UNSW Biological Sciences Project Stage 2

Volume 12: Building Code Report

Design Development Report
BS2-LT161026

RE: BUILDING CODE OF AUSTRALIA ASSESSMENT
BIOLOGICAL SCIENCES PROJECT, BUILDING D26 STAGE 2 SSD APPLICATION (7865)

1
BS2-WB-AR-821

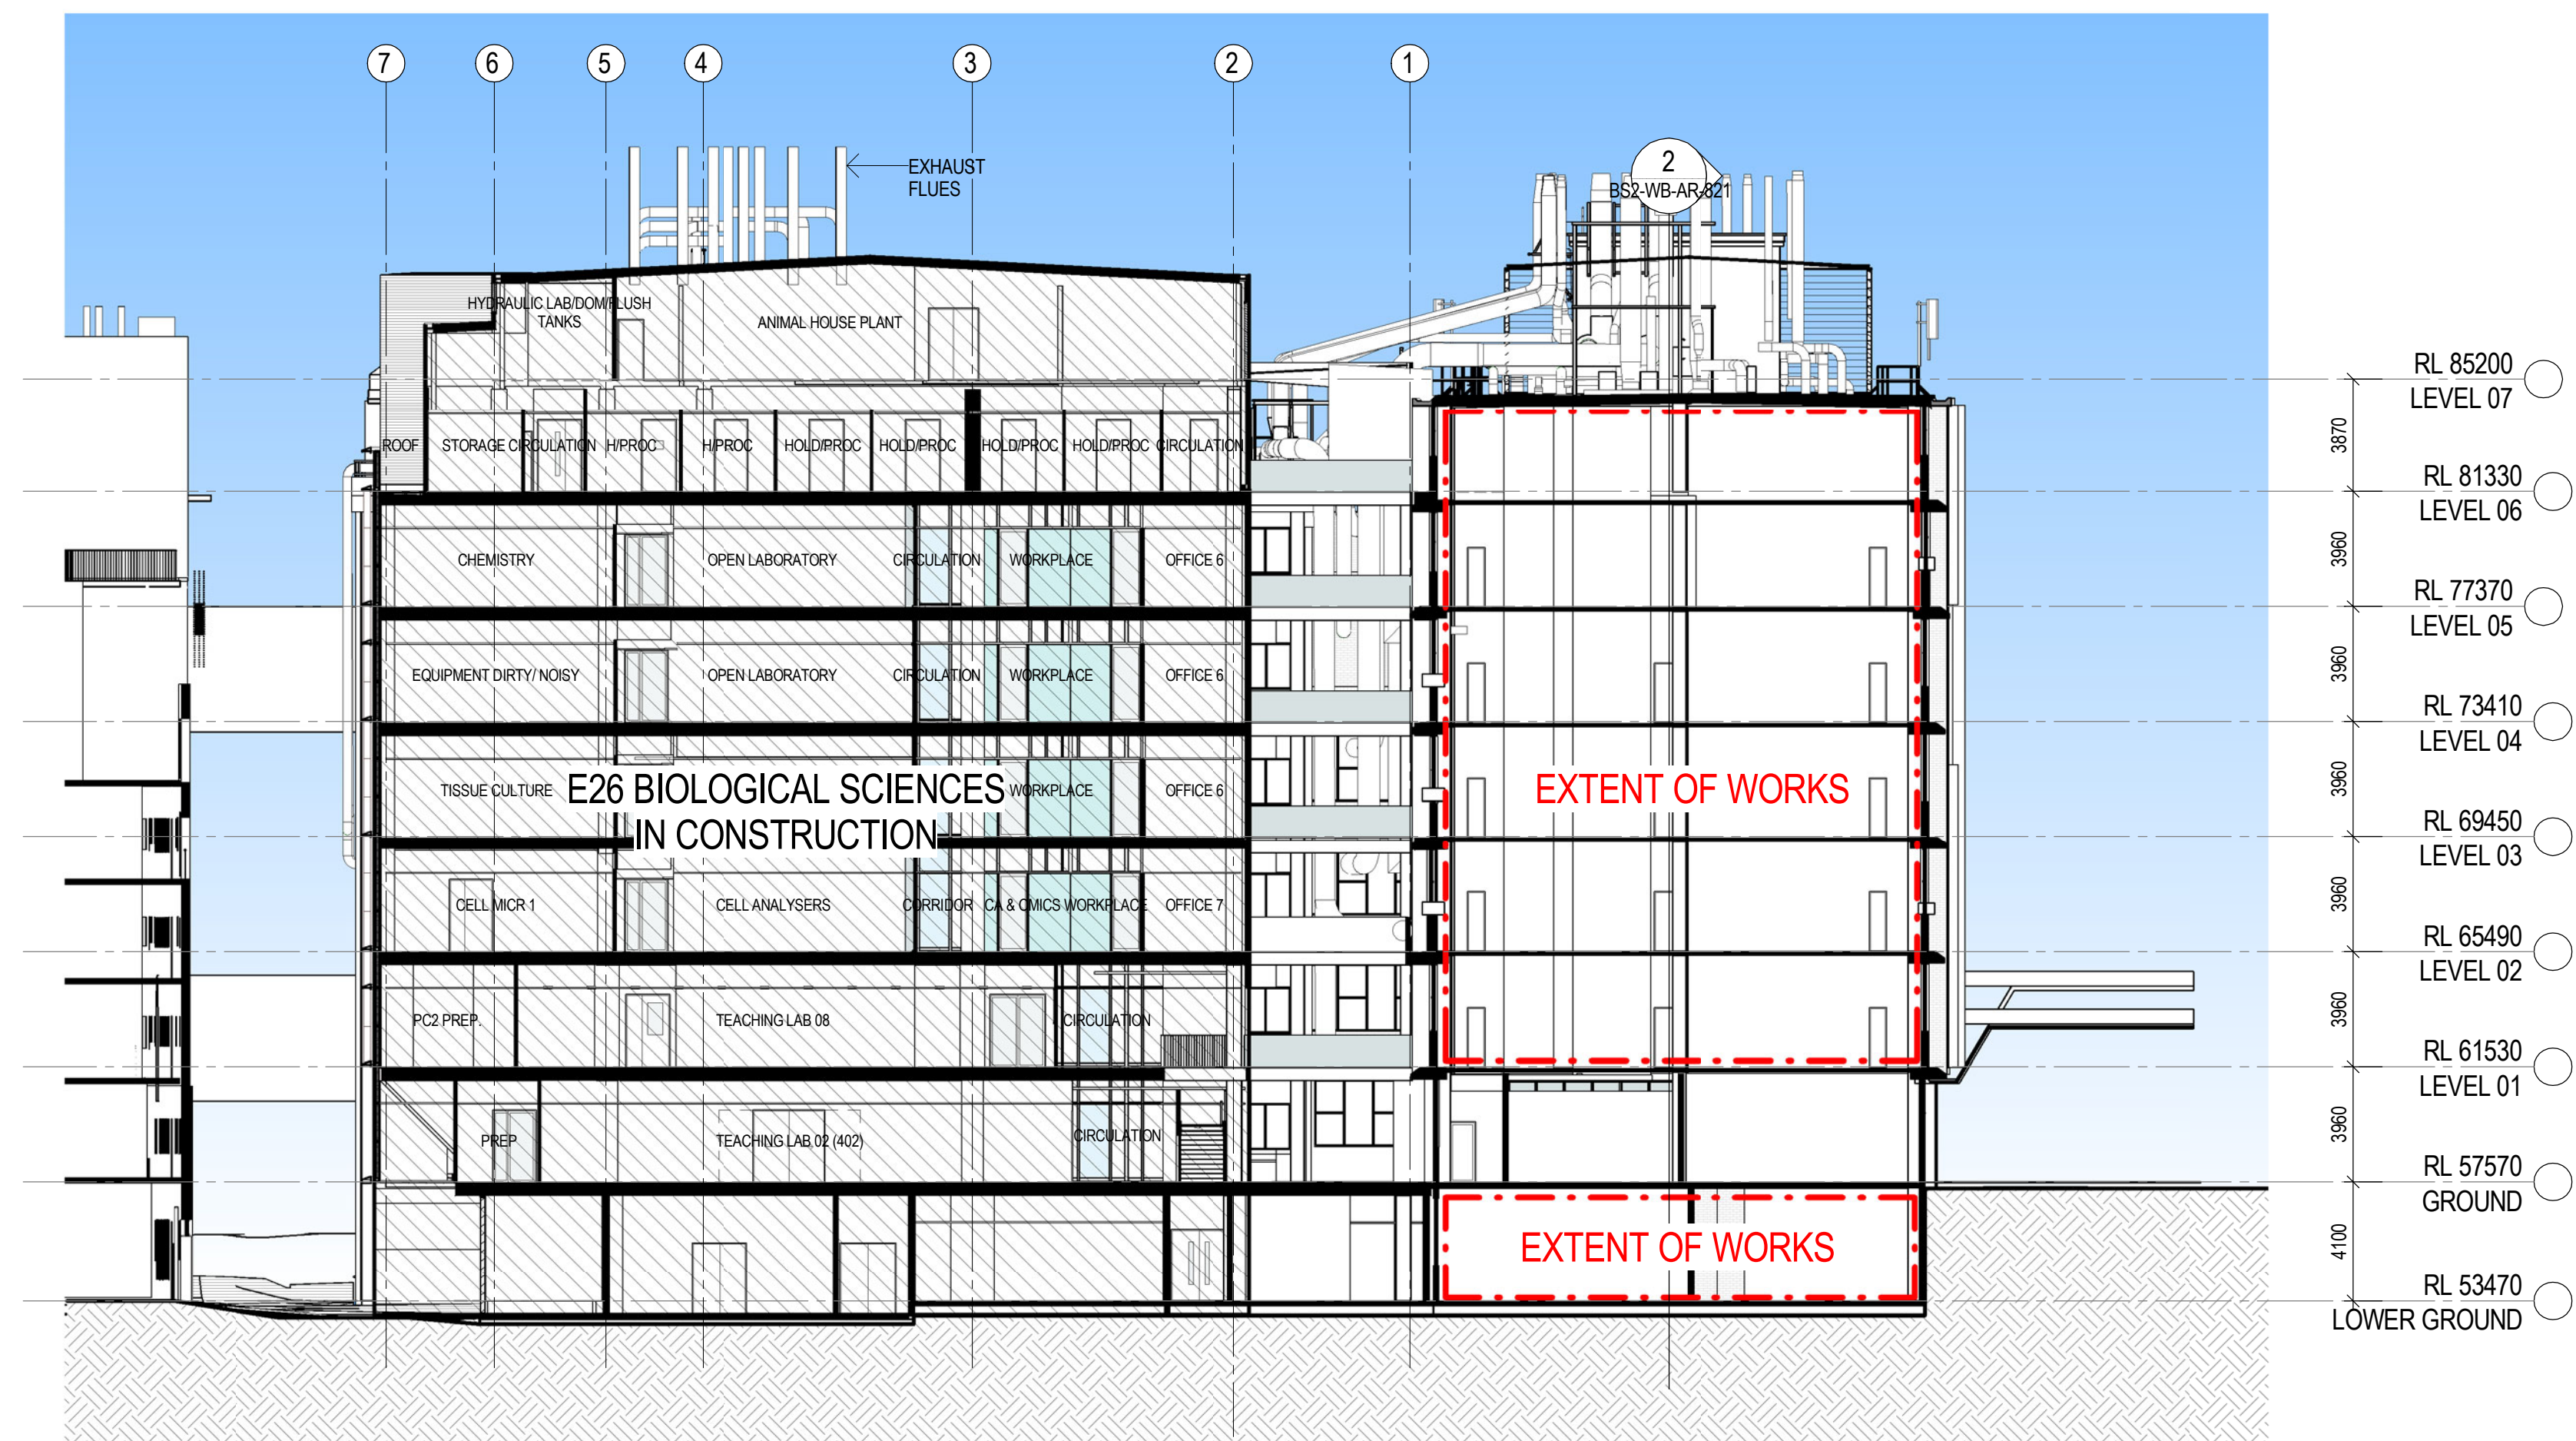
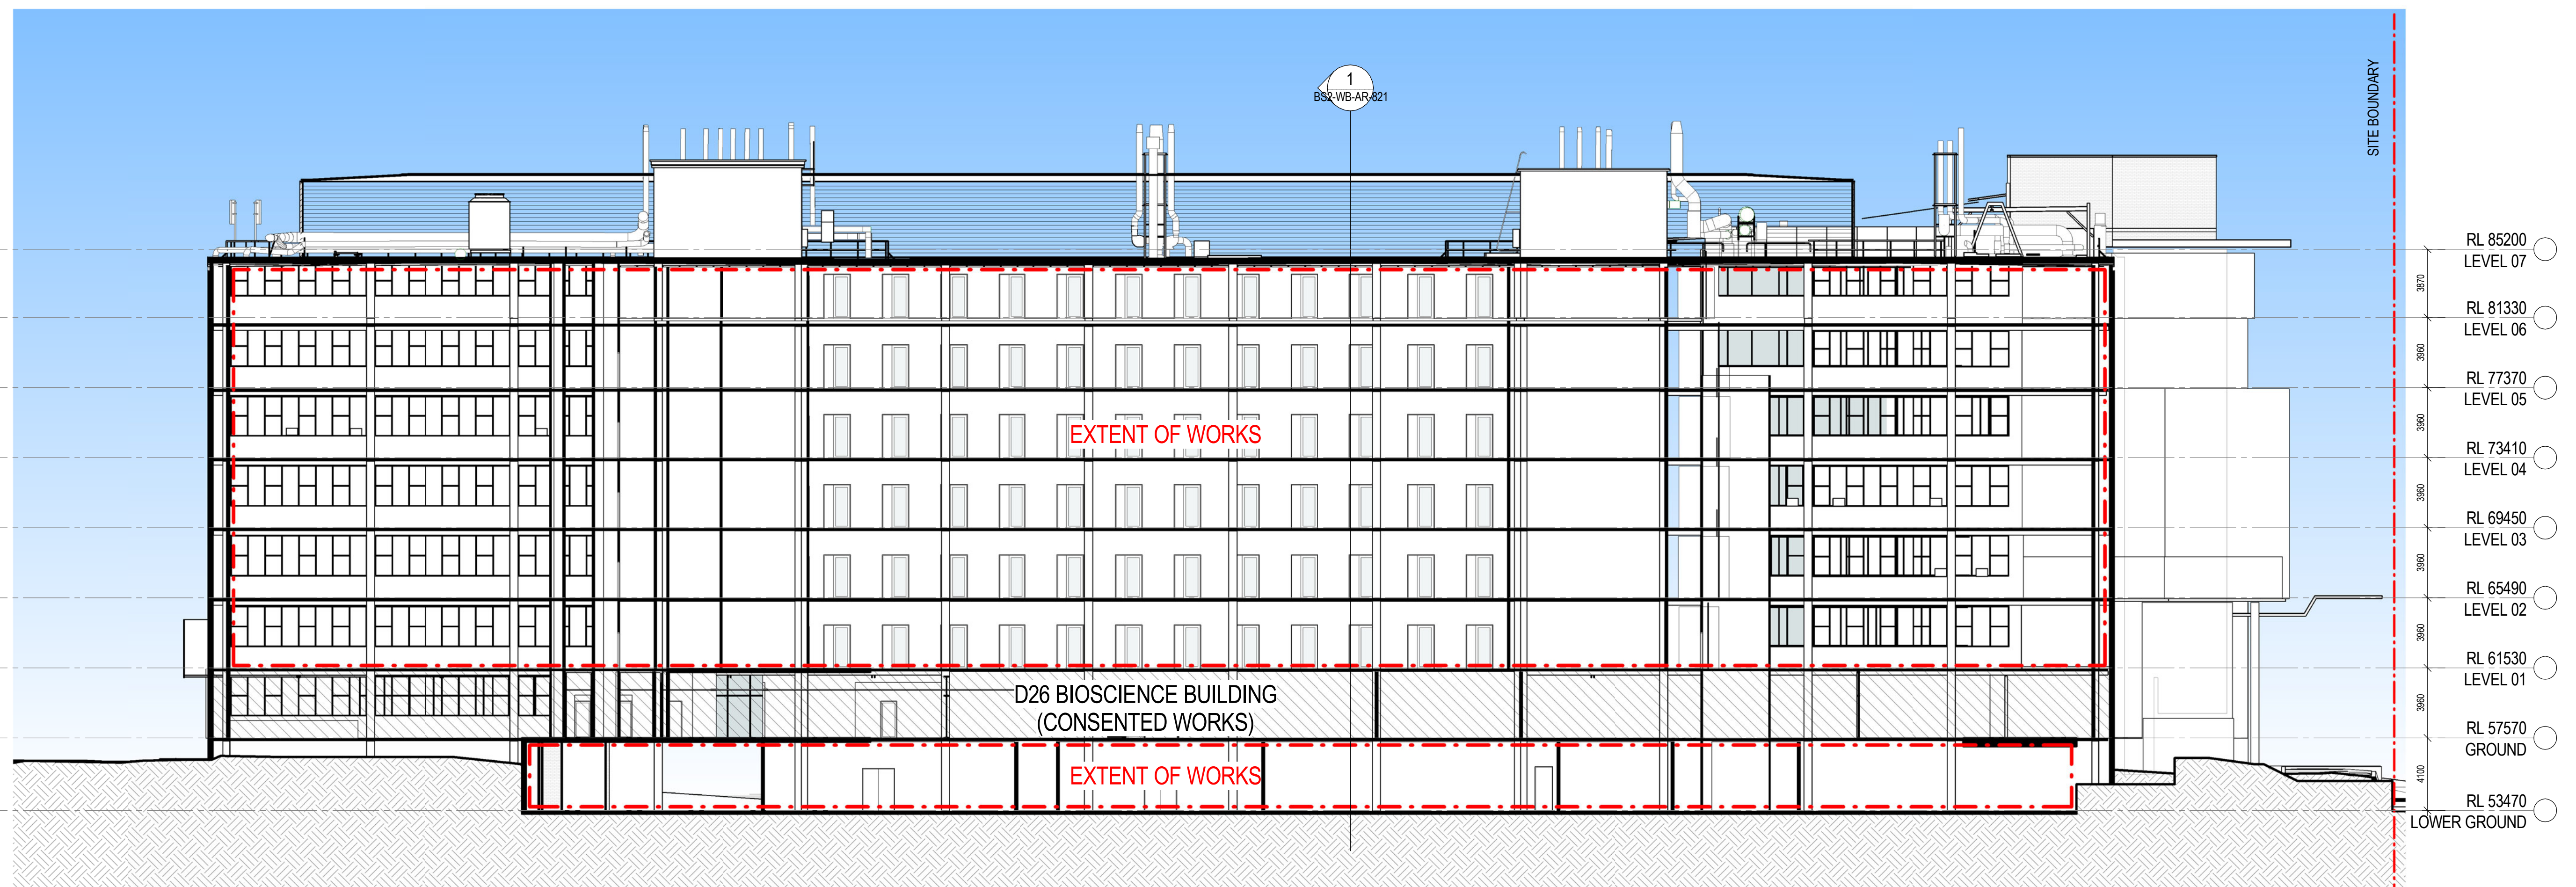
4.2 Compartmentation sizes are increased further beyond BCA DTS limits of 5,000 m² and 30,000 m³. Ground floor to Level 6 Biological sciences building plus D26 (excluding Biolink) will have a fire compartment of approximately 25,948 m². **Performance justification** is required. The Biolink will be a separate fire compartment to D26 and the Biological Sciences building.

9.3 Atrium well is less than 6 m wide (BCA G3.2). **Performance justification** is required.

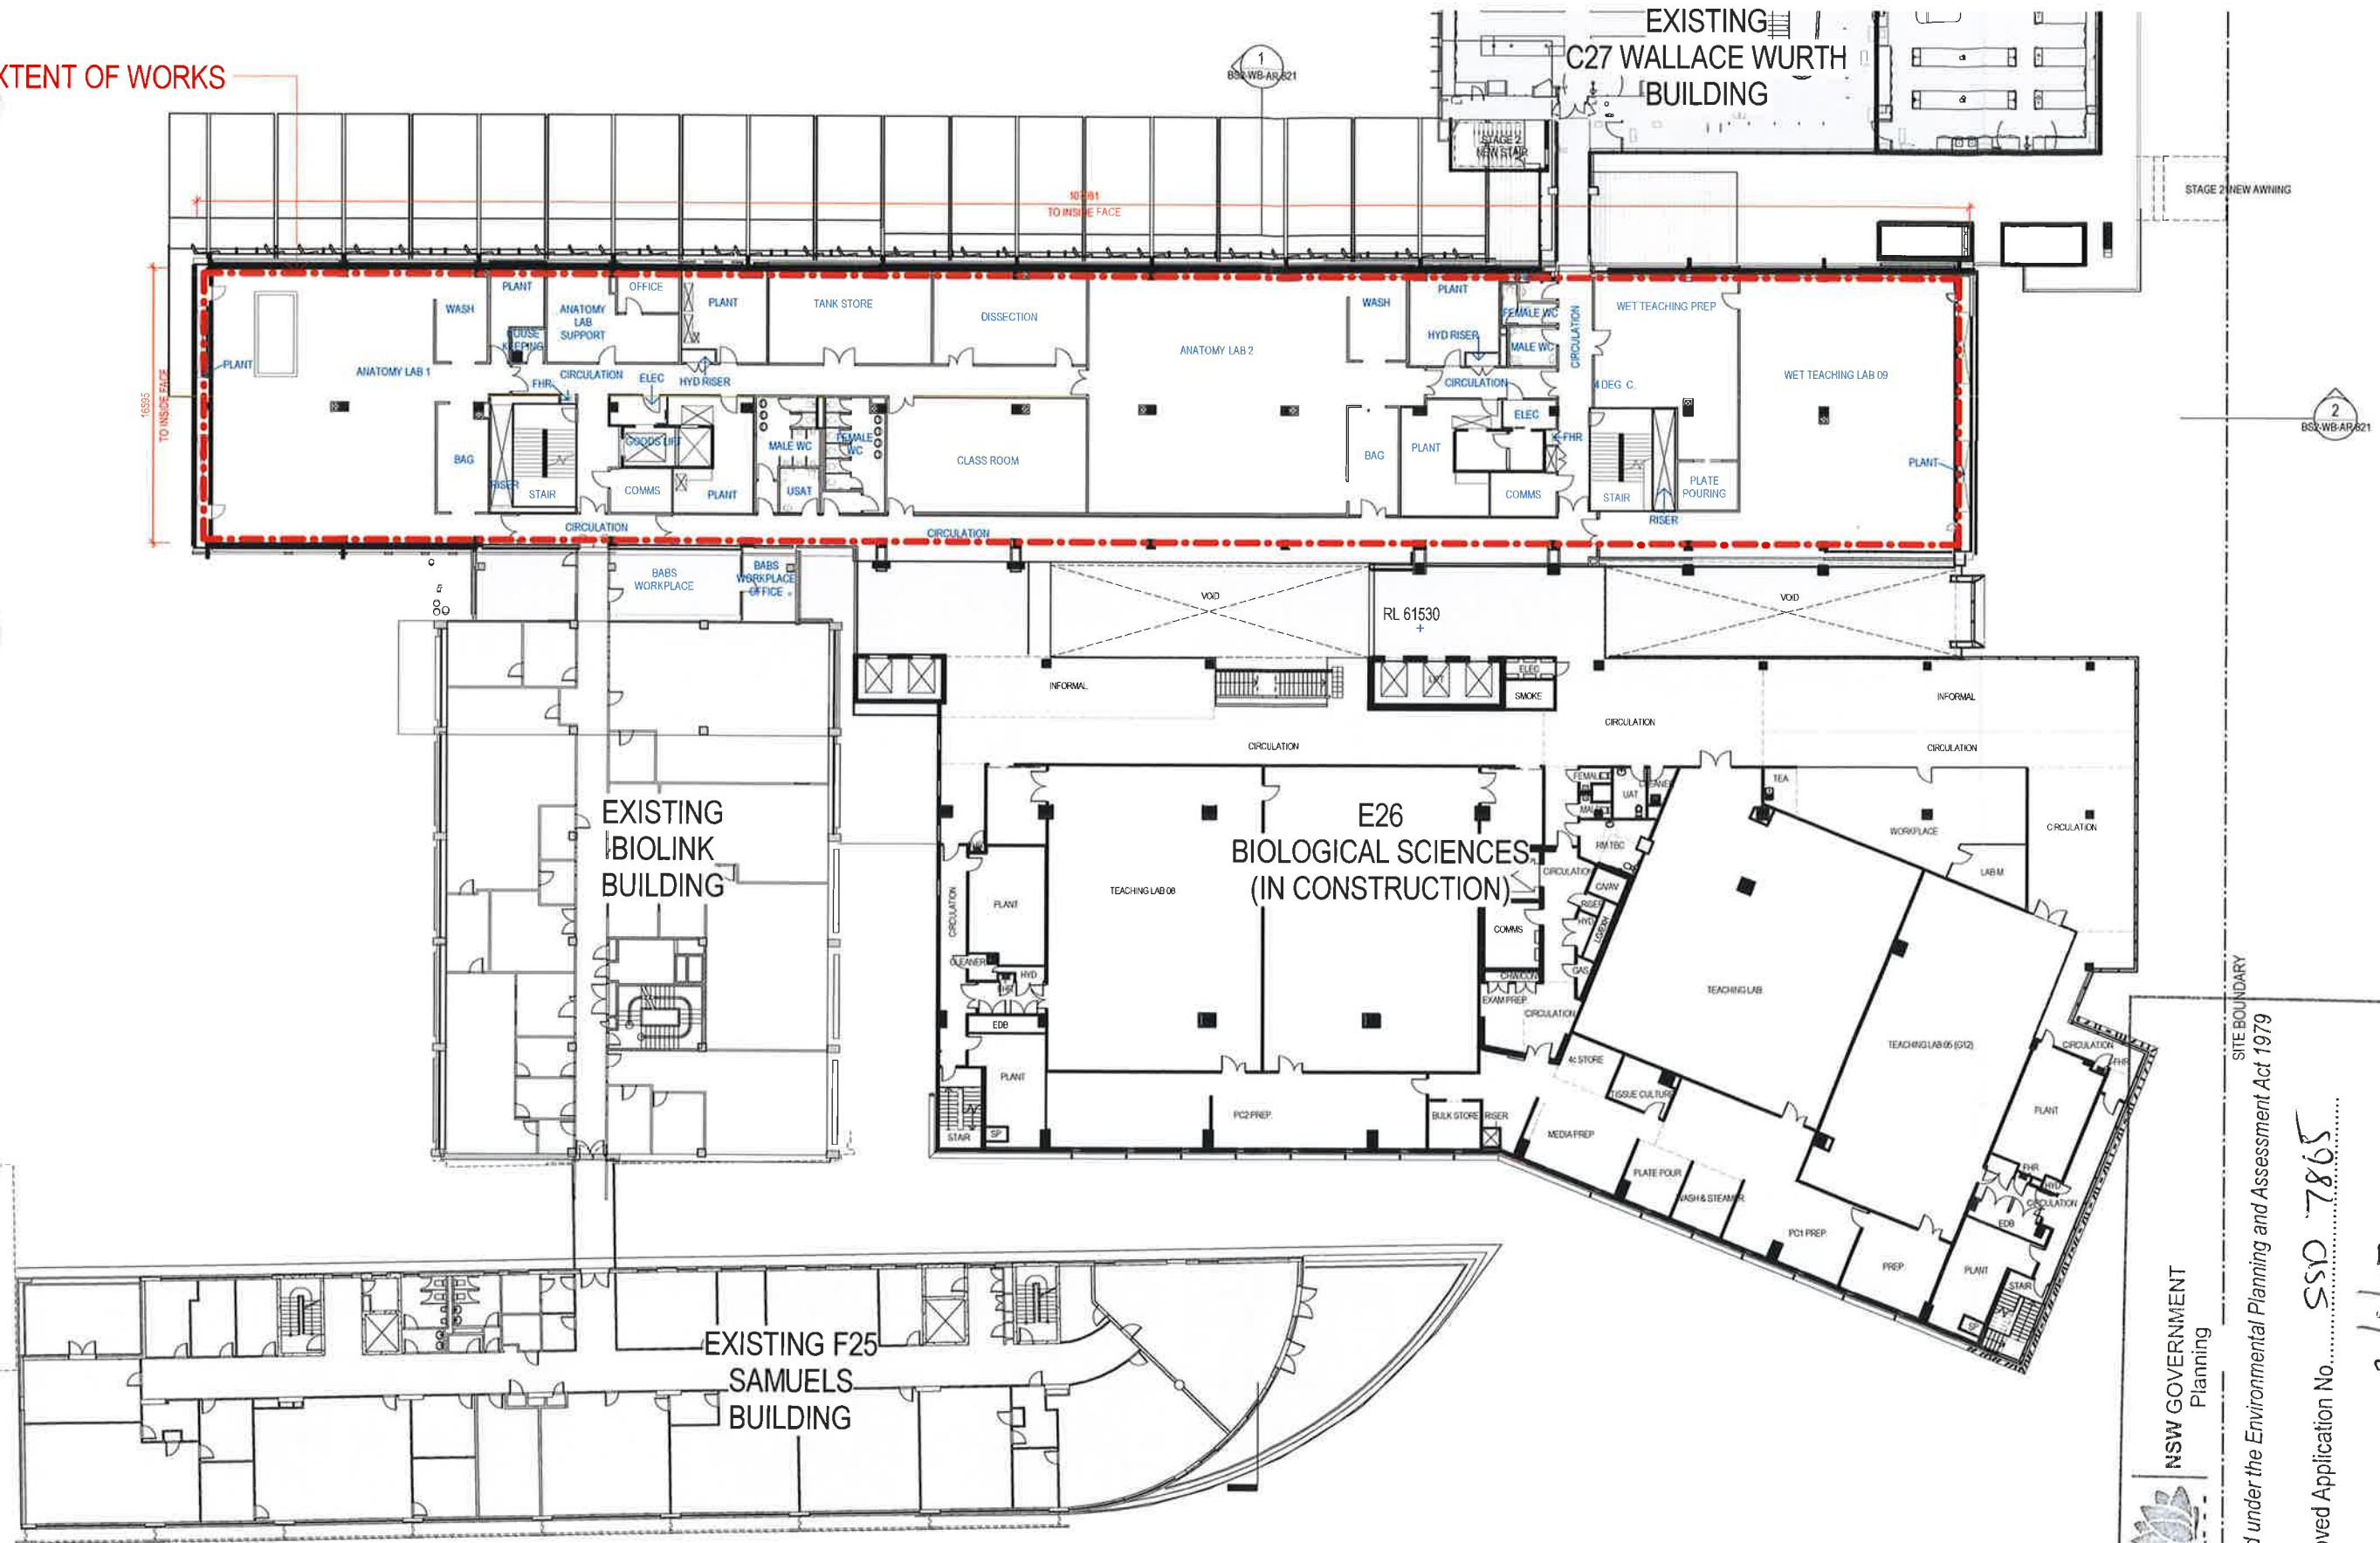
5.4 The LGF main stores room is 51 m from the nearest exit. **Performance justification** is required.

5.6 The LGF door between Building D26 and E26 at eastern end has been assessed as a horizontal exit from the D26 side. The double door is to be redesigned to swing into Building E26.

(a) LGF D26 west stair to east horizontal exit – 71 m.
